**Whytes Gully Landfill Expansion Project, Kembla Grange (11_0094)
Exhibition of Environmental Assessment – Submission from NSW EPA**

Environment Protection Authority Submission
Comments and Recommended Conditions of Approval
Whytes Gully Landfill Expansion Project, Kembla Grange (11 0094)

Figure 5: Noise Receivers

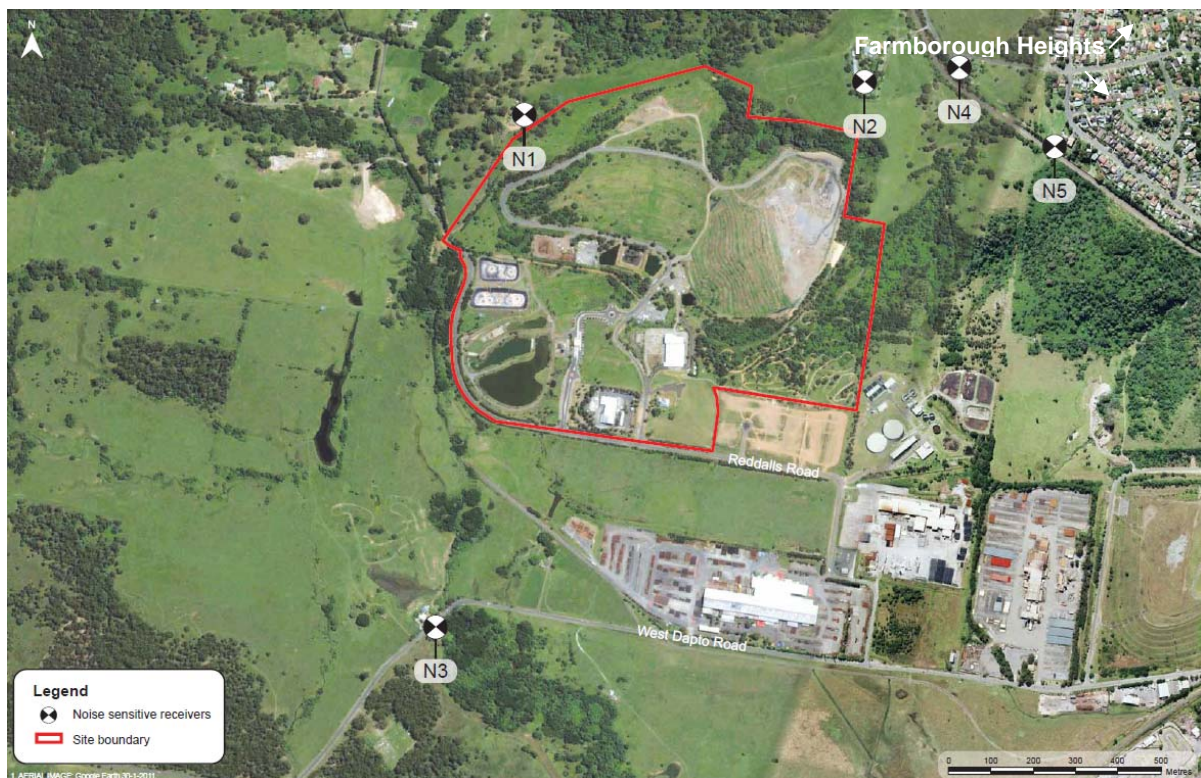
The cumulative (i.e. construction and operation) predicted noise levels at receivers N1 and N2 are significantly greater than the Project Specific Noise Level (PSNL) - up to 54dBA at N1 and up to 45dBA at N2. The proponent has not provided any description of feasible and reasonable mitigation measures to reduce the predicted levels. The EPA advises that it does not normally Licence to levels significantly greater than the PSNLs.

The EPA has not included receivers N1 and N2 in the noise limits table in the attached recommended licence conditions, on the assumption that Planning will advise the proponent that the negotiated agreements process in Chapter 8 of the INP is available to them, and that Planning will require the proponent to provide evidence of negotiated agreements being in place with N1 and N2 before any Project Approval can be issued.
